From: Anita Gardner
Sent: 26 July 2018 17:38
To: Planning.Responses
Subject: FW: 8 Duncton Road, Rustington, BN16 3LA, R/134/18/PL

From: [REDACTED]
Sent: 26 July 2018 17:34
To: Planning.Responses; Anita Gardner
Cc: Ward, Stuart
Subject: 8 Duncton Road, Rustington, BN16 3LA, R/134/18/PL

Drawing P01      May 2018      Scale 1:100 @ A3  
Planning Drawing - Site Plan & Floor Plans

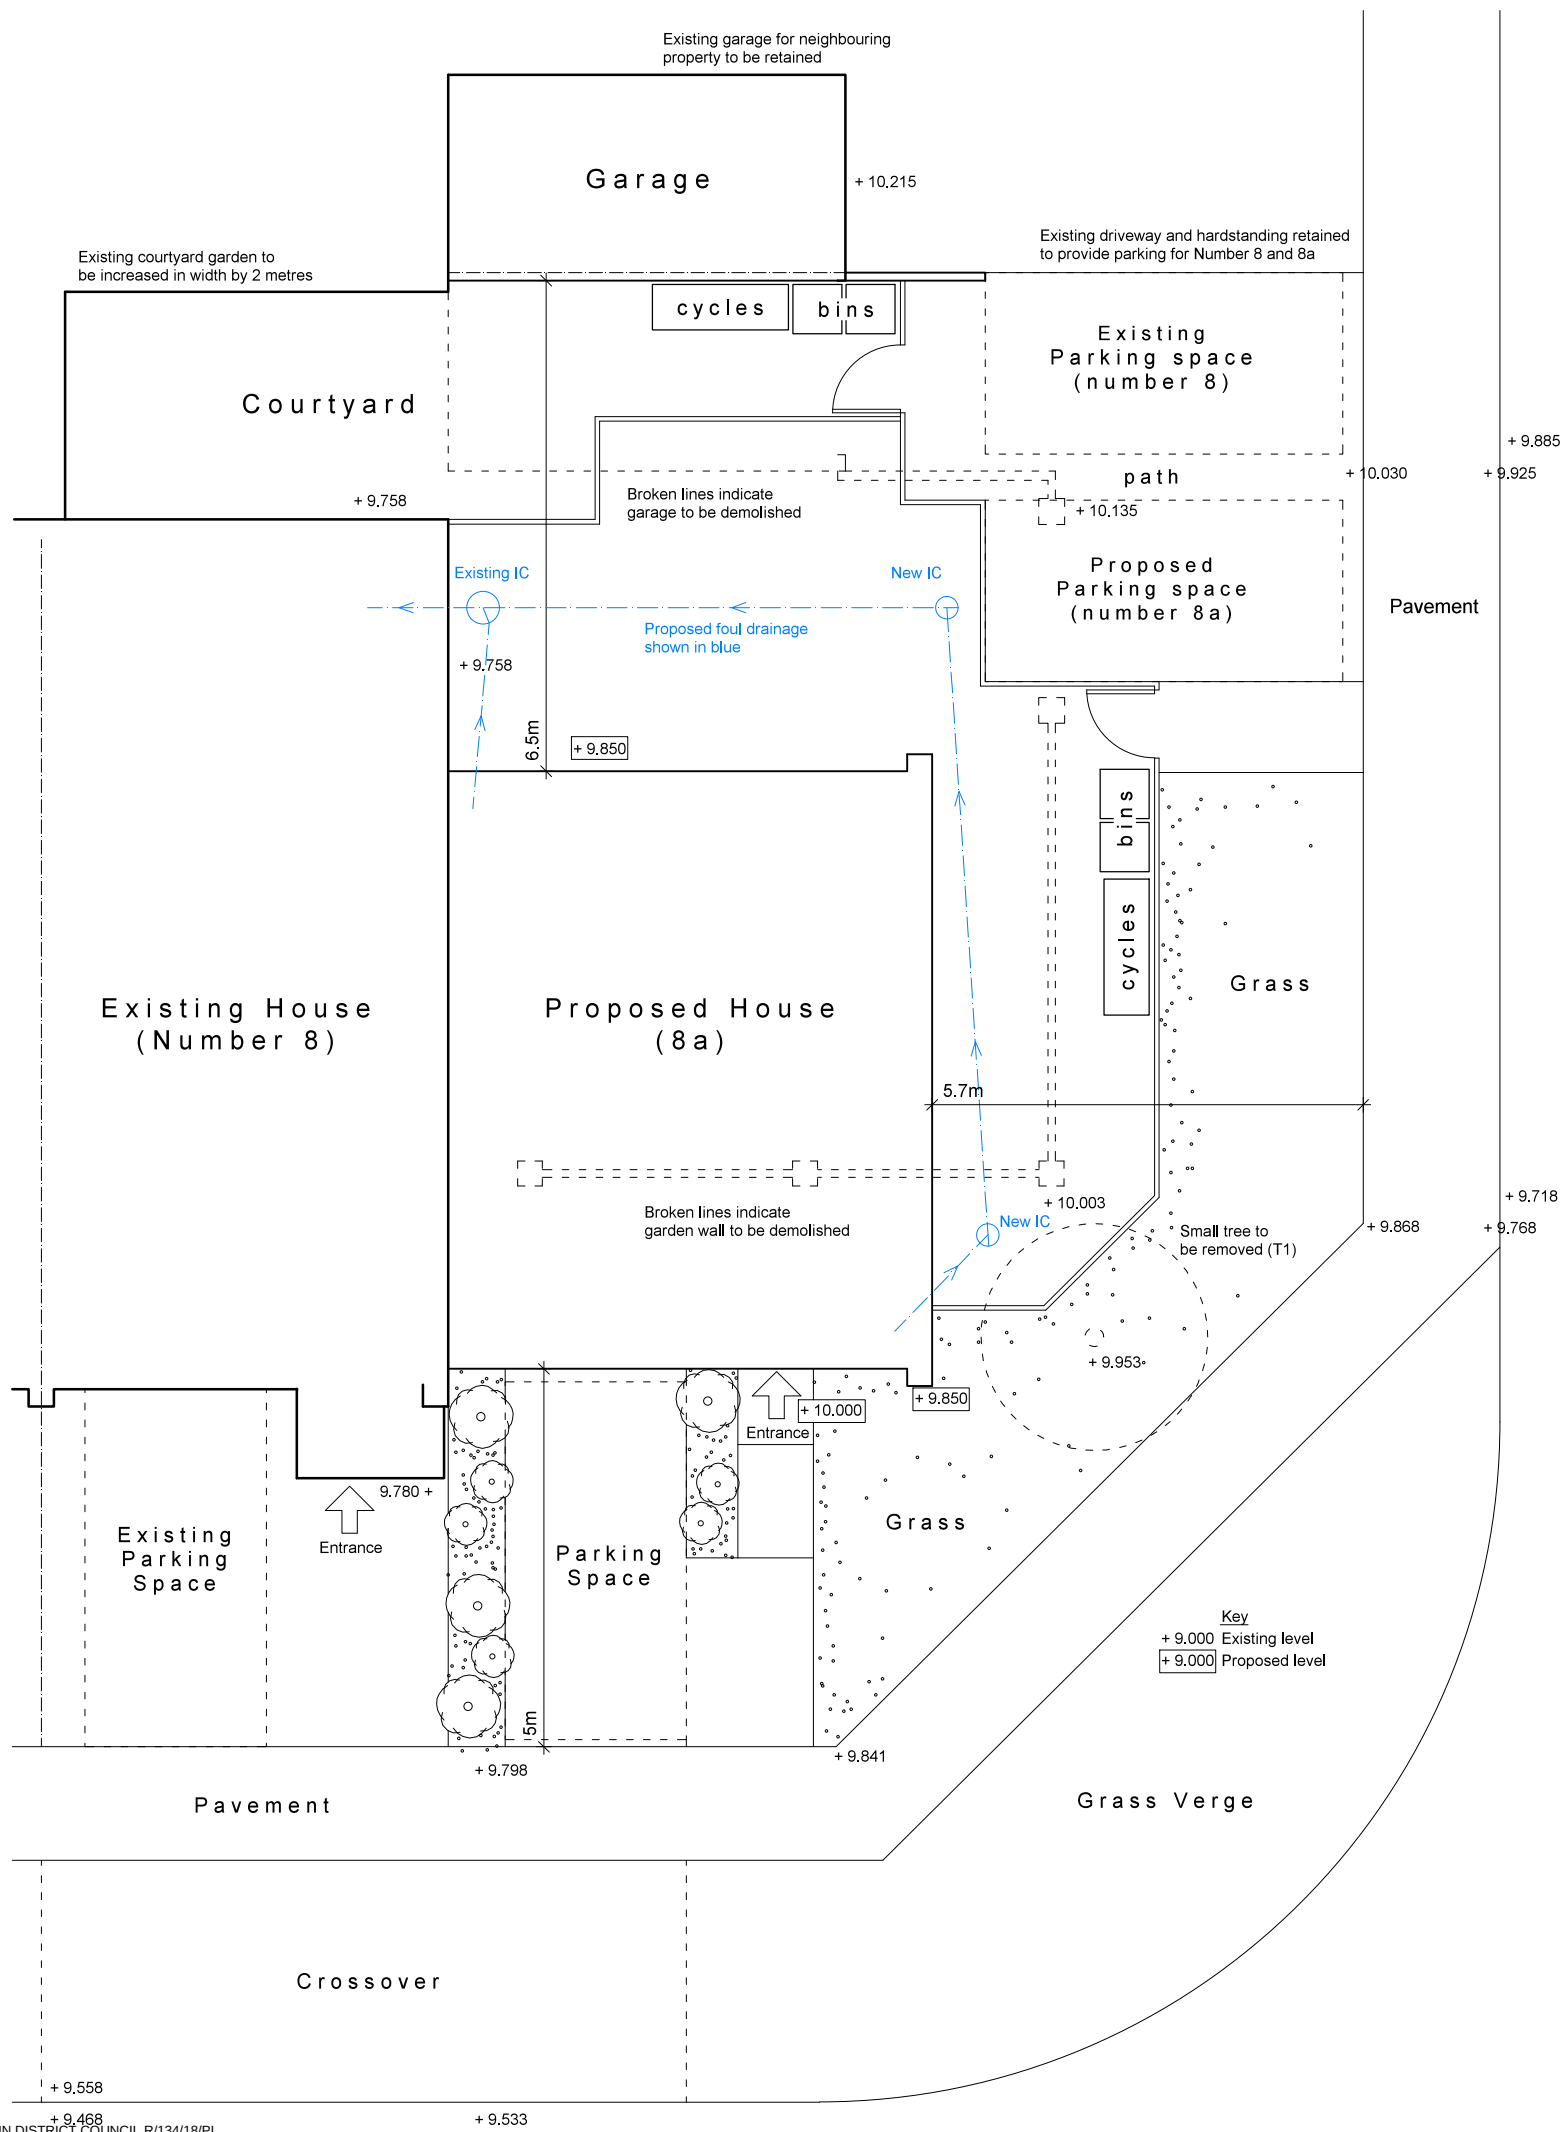
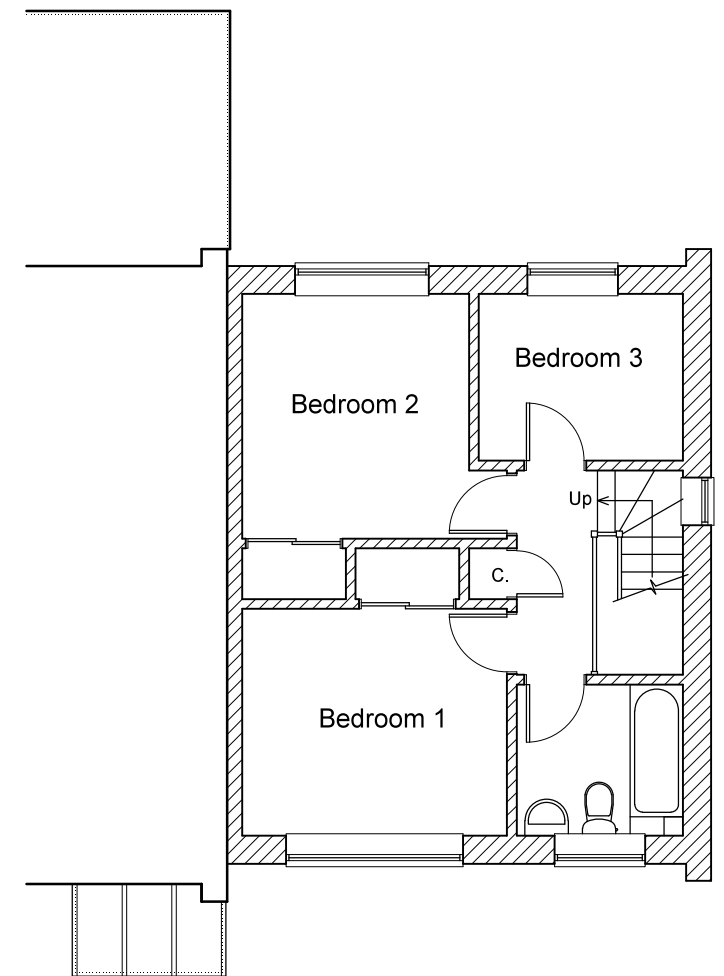
It came to our attention that we have not been consulted in regards to the above development and the developer intends to connect surface water into public foul sewers which is not acceptable to Southern Water, therefore we object the discharge of surface water into foul system.

Please confirm that surface water will not be discharged into the foul system.

Please note that surface water should be disposed in compliance with Part H3 of the Building regulations as per below.

" It is the responsibility of the developer to make suitable provision for the disposal of surface water. Part H3 of the Building Regulations prioritises the means of surface water disposal in the order

- a Adequate soakaway or infiltration system
- b Water course
- c Where neither of the above is practicable sewer
